From: Kate Giddings <kate.giddings@arun.gov.uk>
Sent: 29 January 2021 11:54
To: Anita Gardner <Anita.Gardner@arun.gov.uk>
Cc: Planning.Responses <Planning.Responses@arun.gov.uk>
Subject: FW: R/227/20/PL - 38 Oakhurst Gardens, Rustington, BN16 3AW

Subject: R/227/20/PL - 38 Oakhurst Gardens, Rustington, BN16 3AW

In relation to the above application, please may EH comment as follows:

Project	Laundry & Accommodation Oakhurst Gardens			Project No.
				010
Client	Littlehampton & Rustington Housing Society			
Date		Drawn	ES	Issue
Scale / Format	1:50 @ A1 1:100 @ A3	Checked	JT	P1
CAD Reference		Approved	SM	
Drawing Name	Laundry Elevations	Drawing No.	010-P-40-03

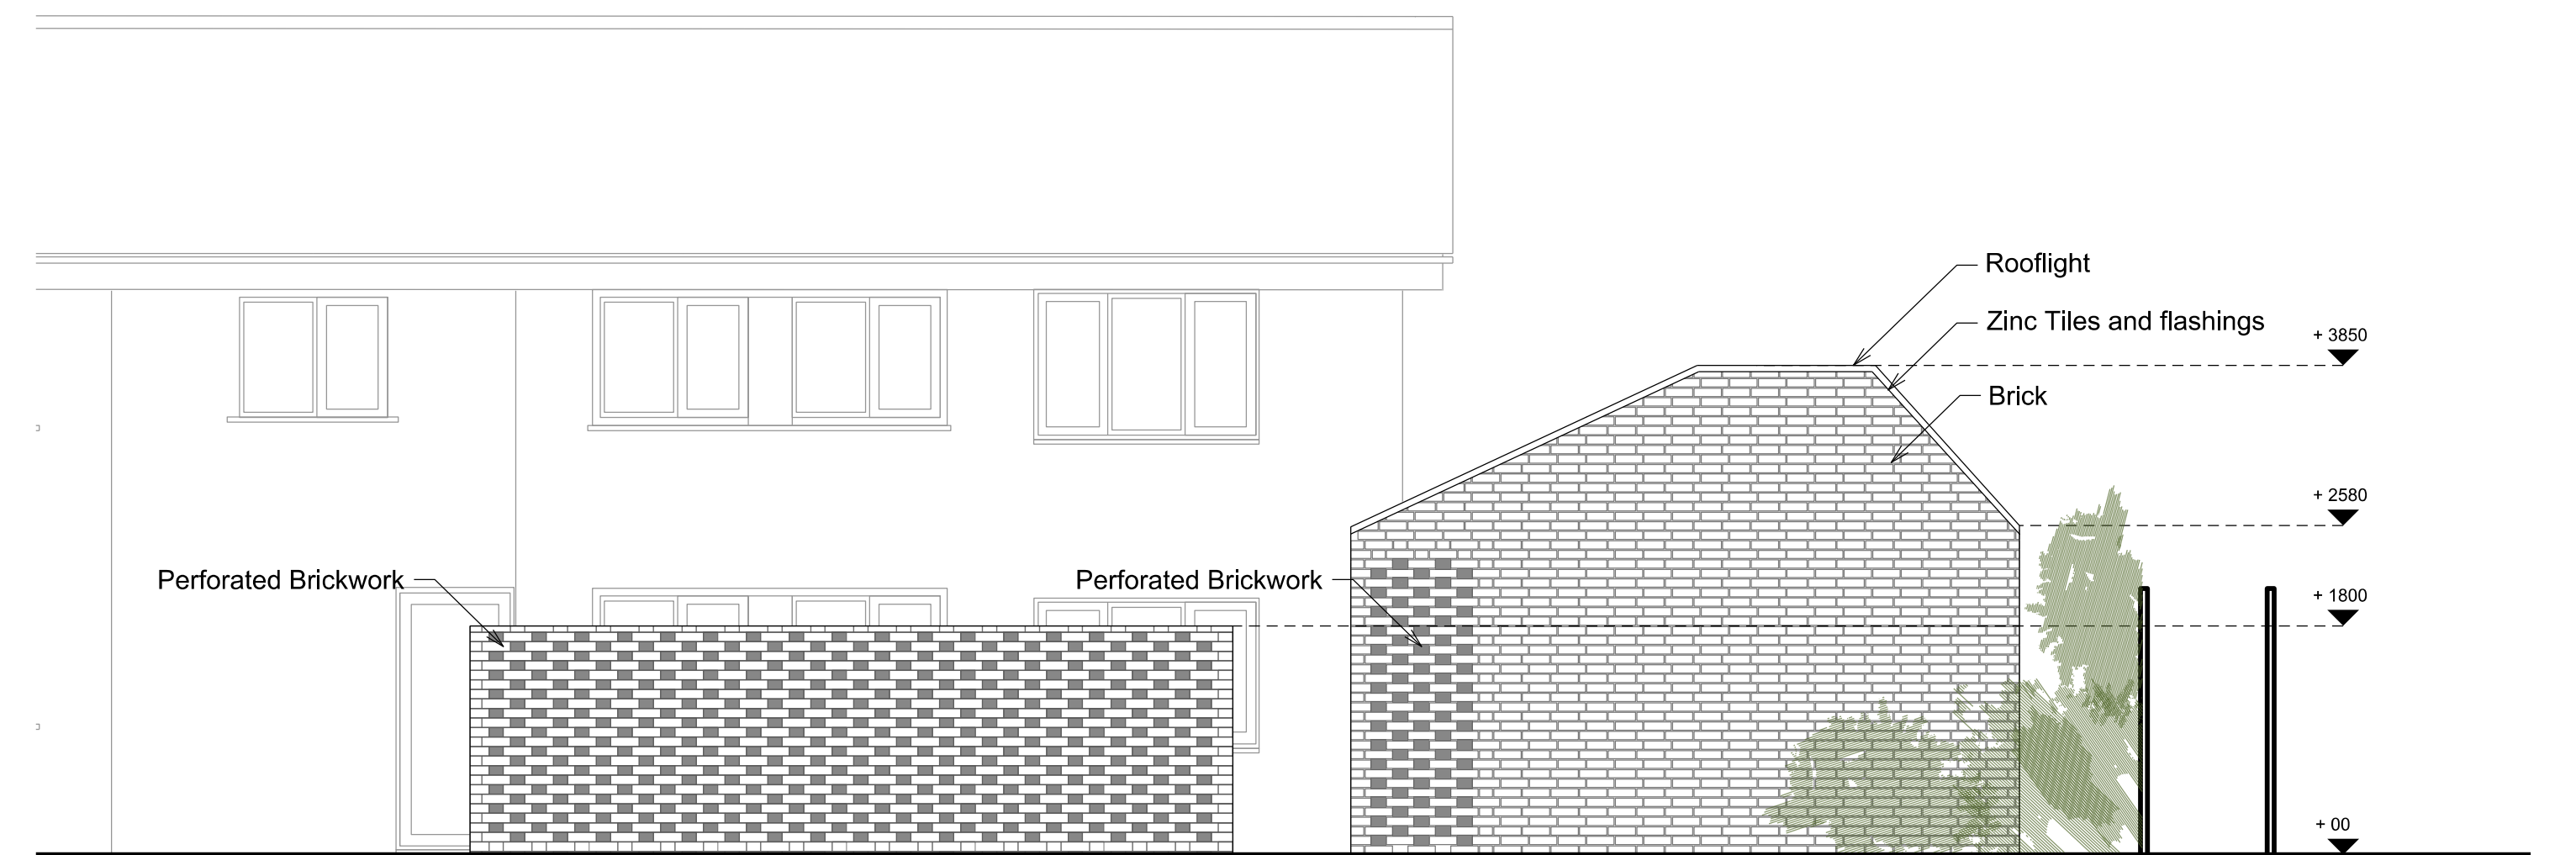
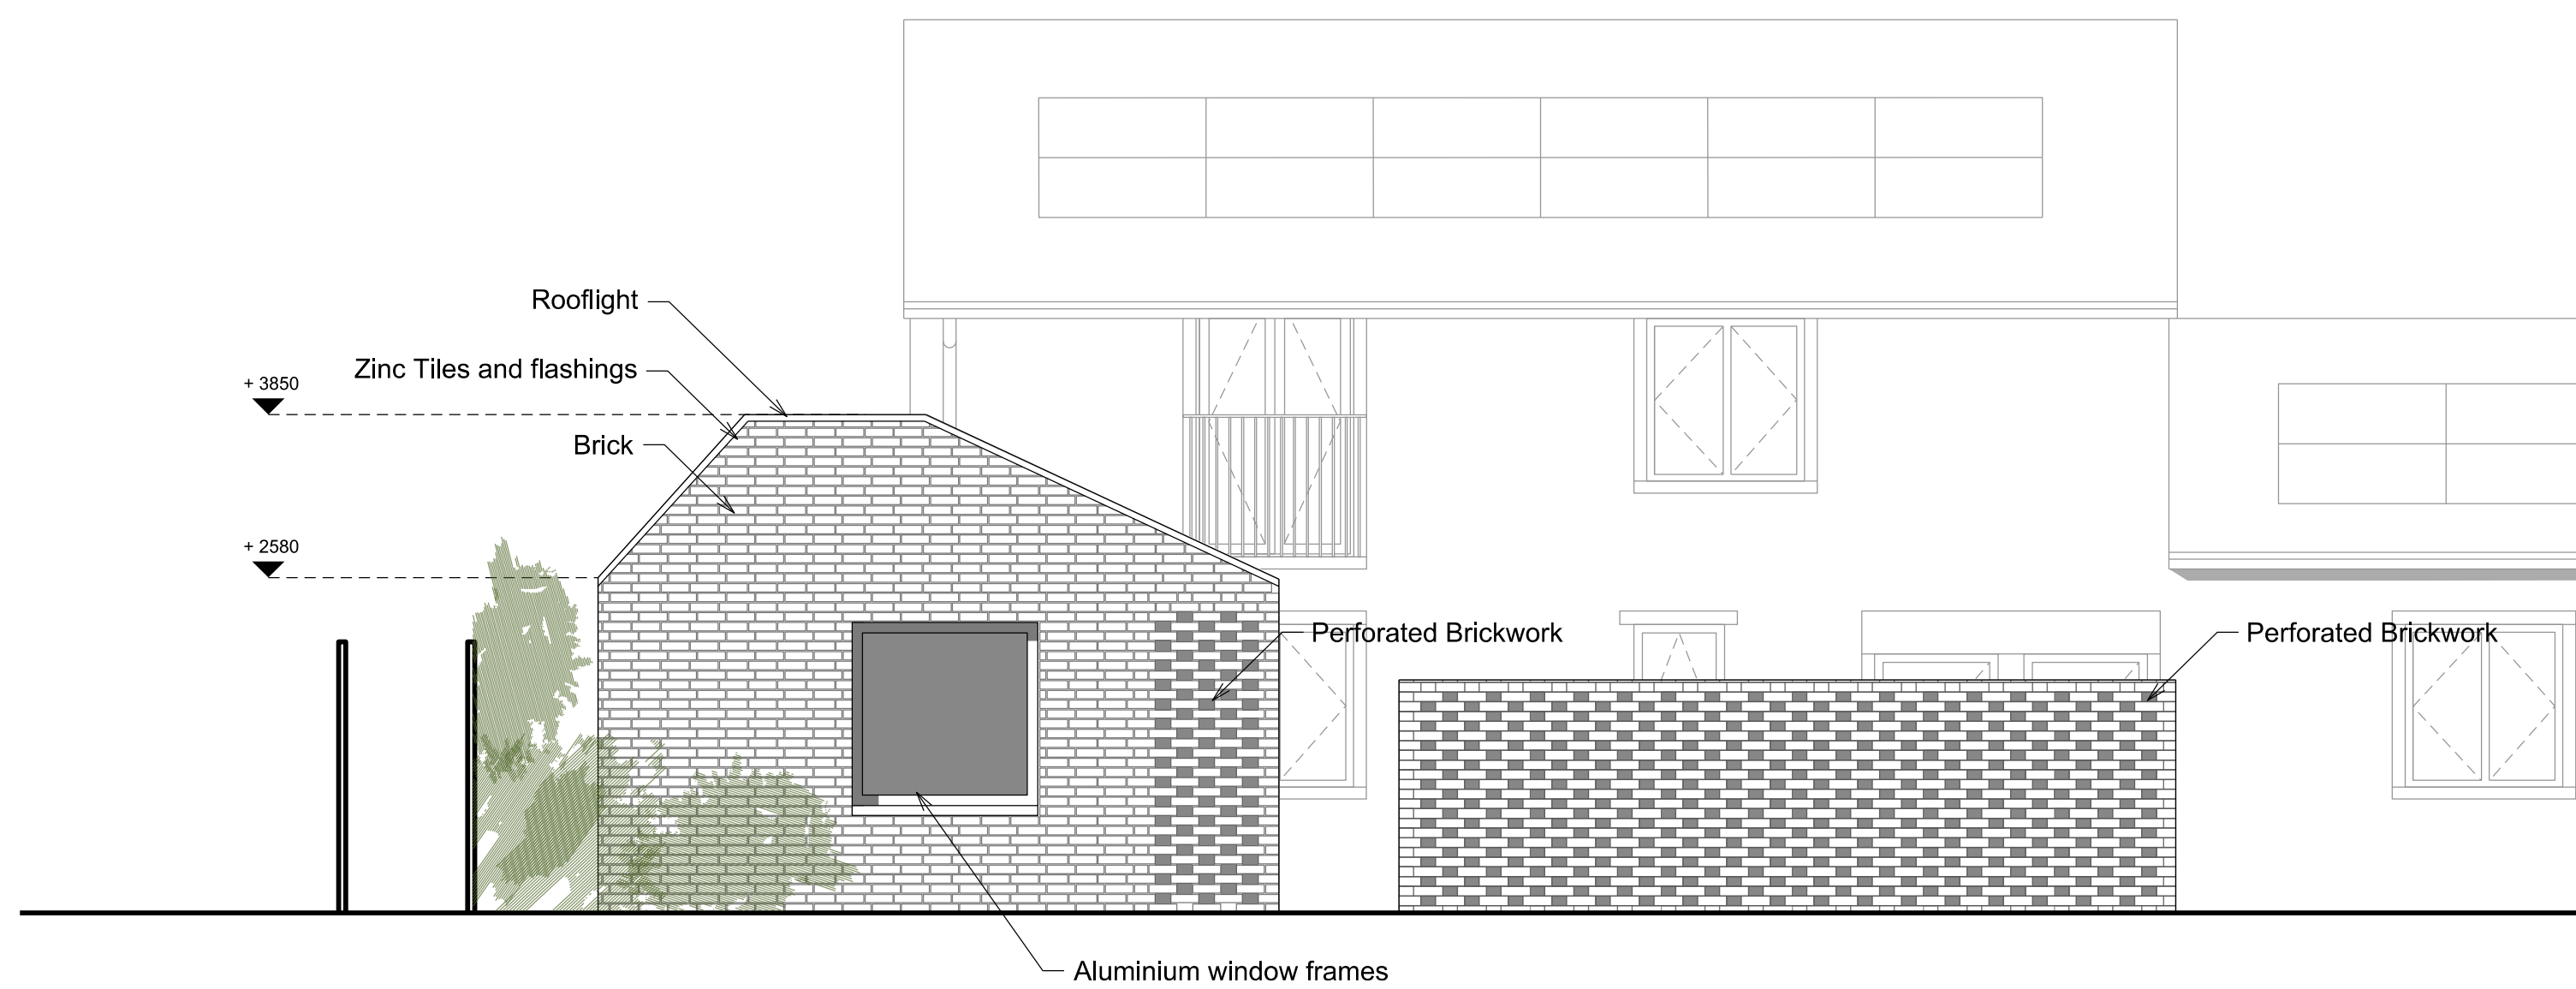
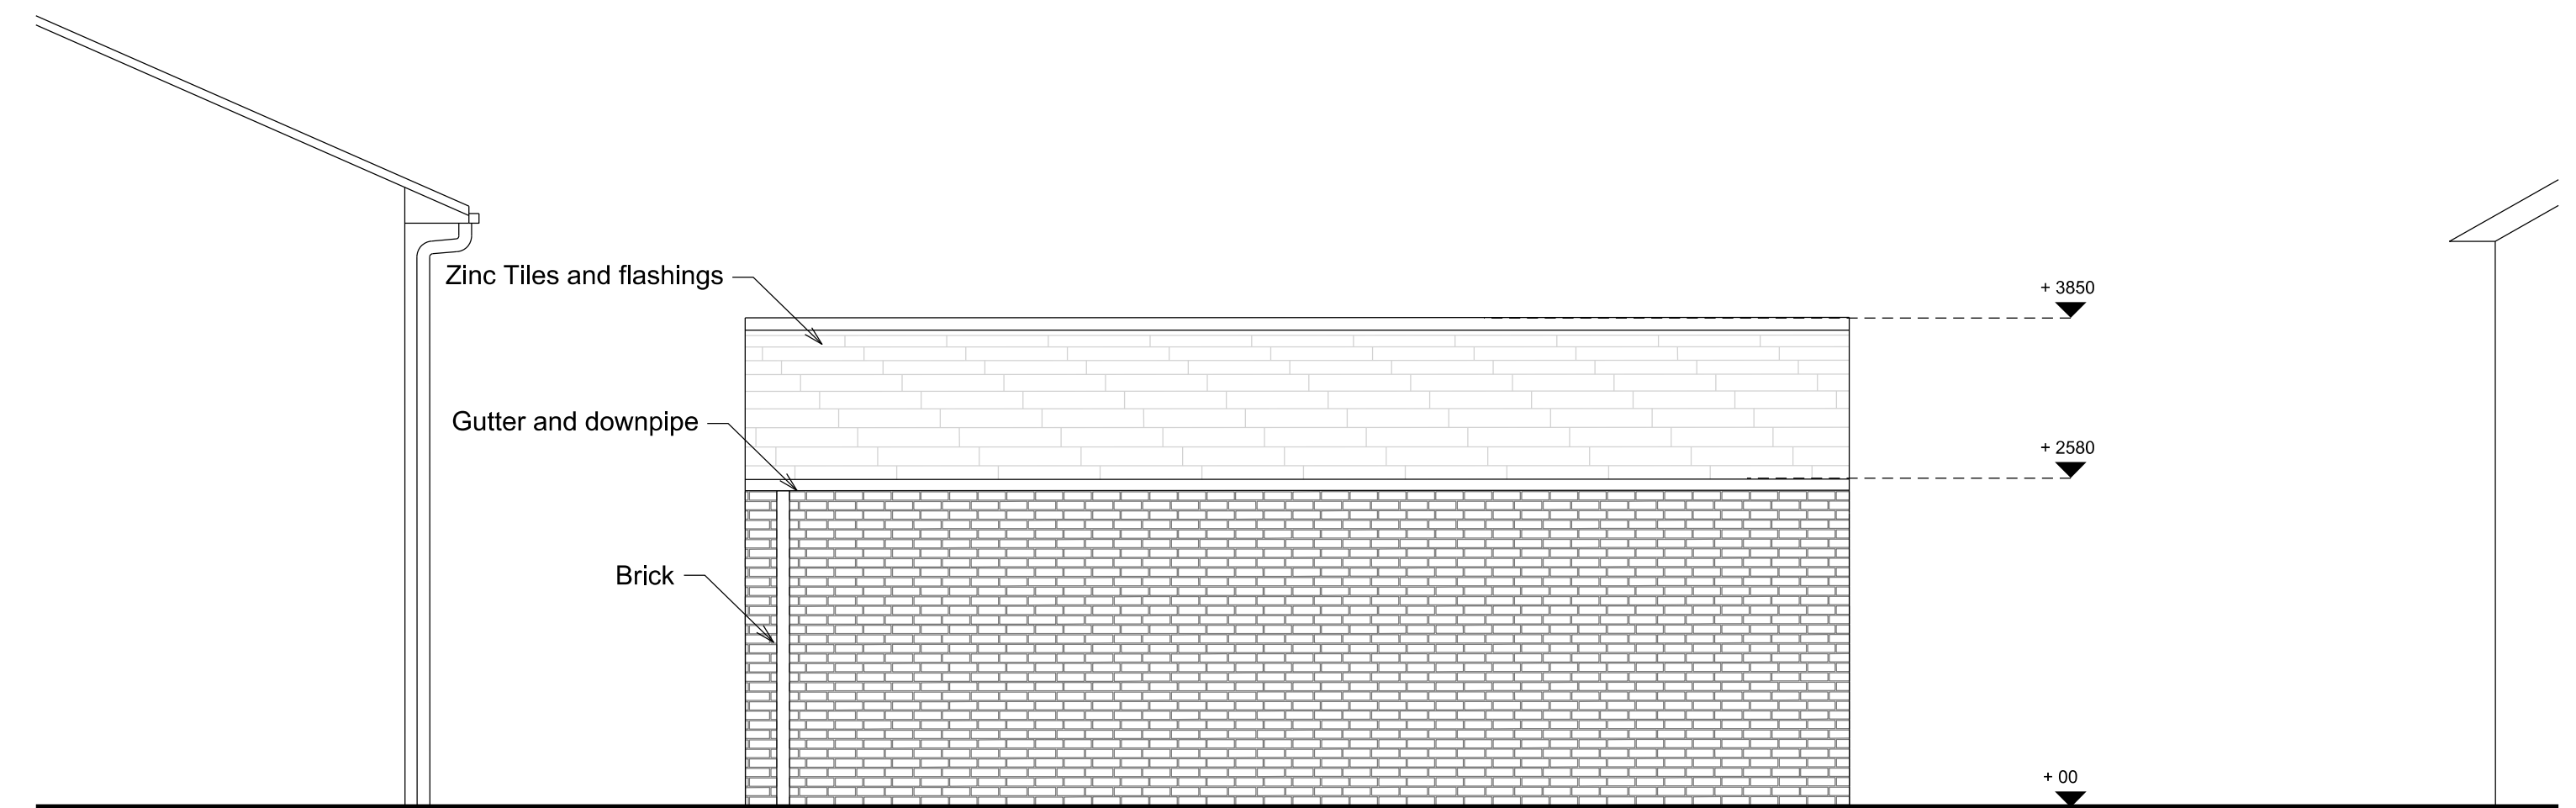
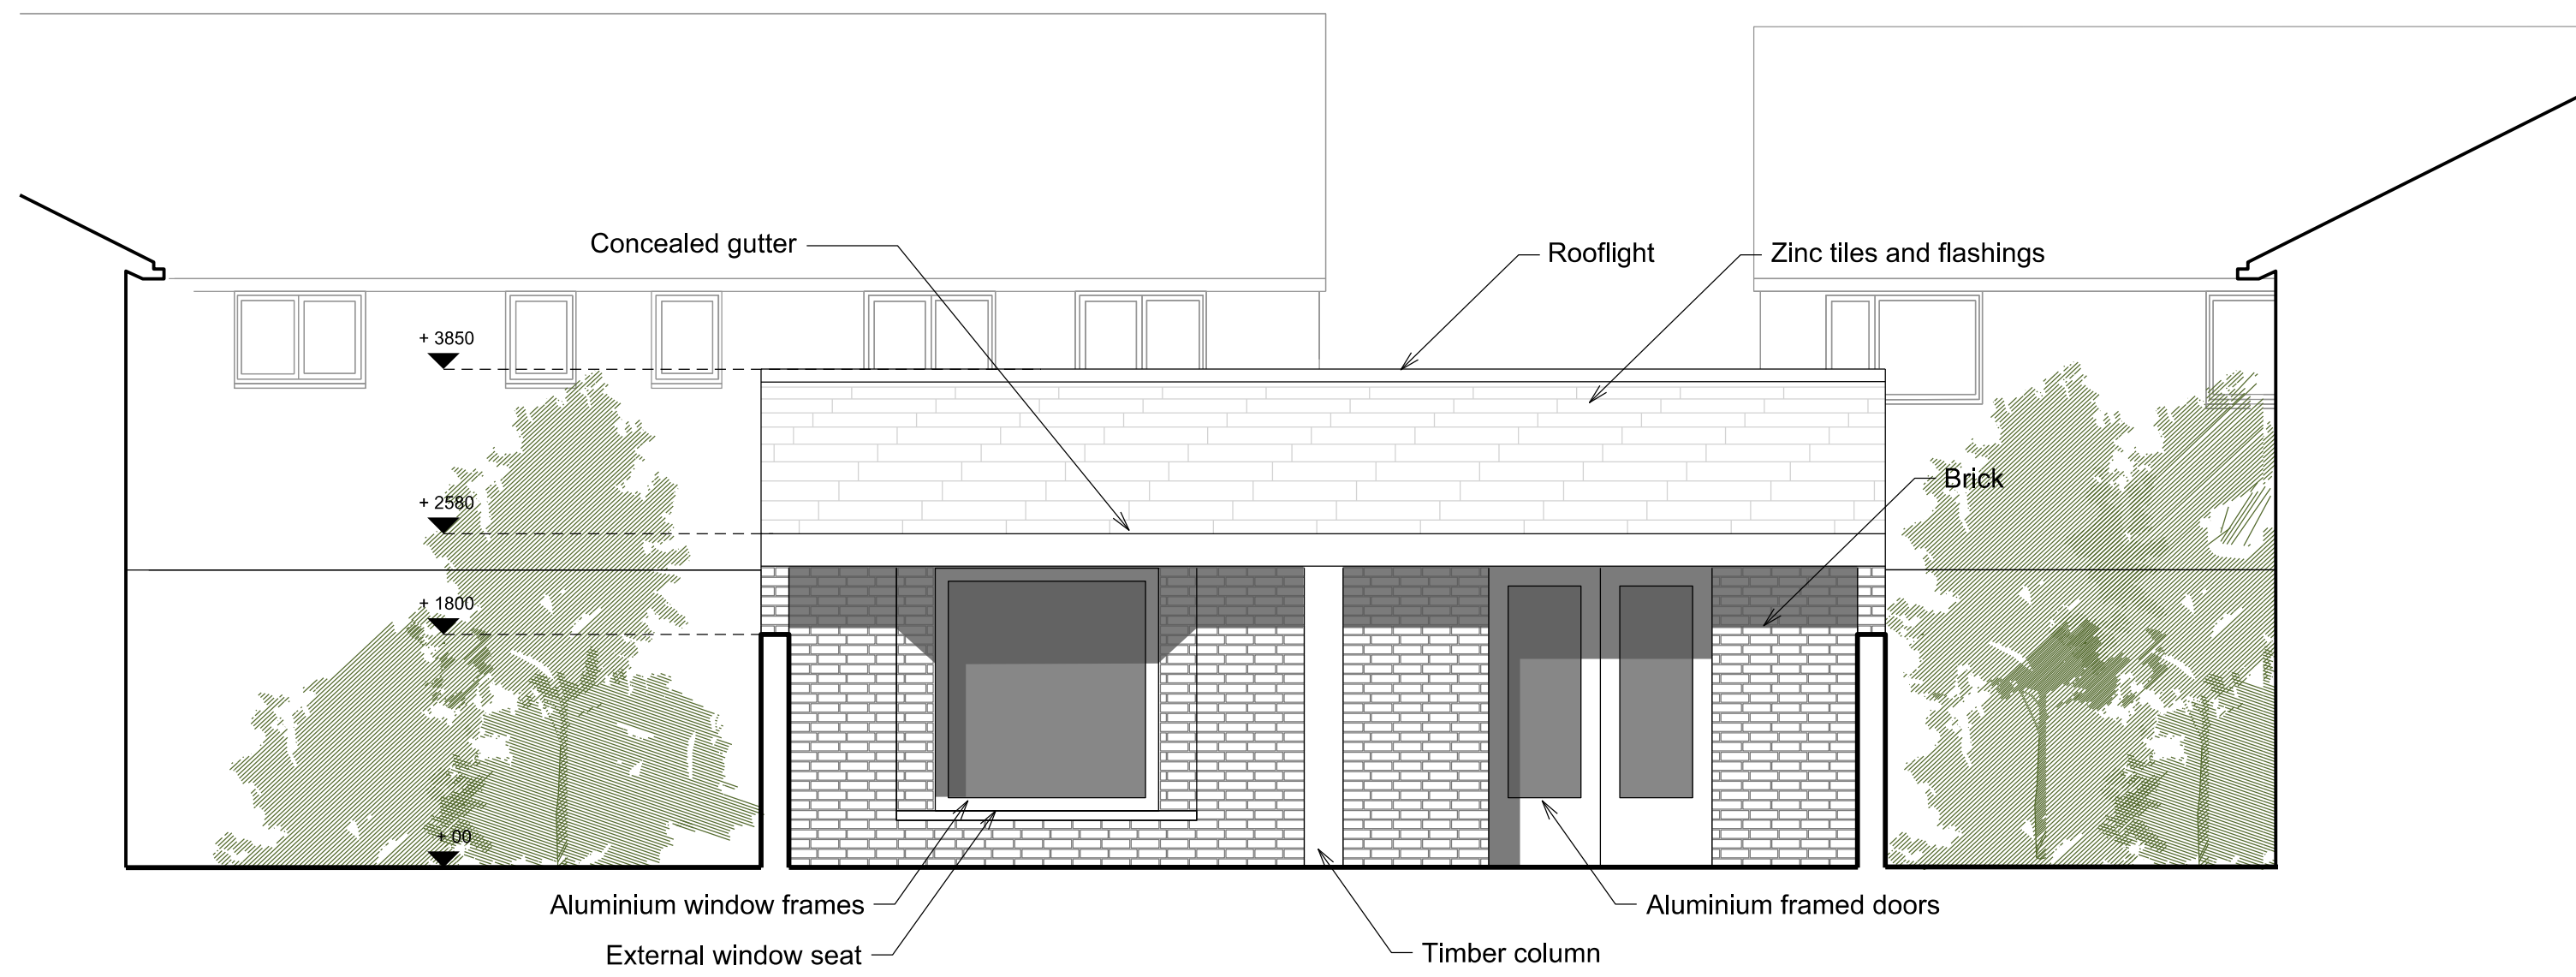
In addition, please may more detail be provided on the proposed laundry building; for example, will there be any measures in place to minimise the noise and vibration from the equipment and any associated ducting and if there are to be outlets for dryers, etc., how will the emission be managed?
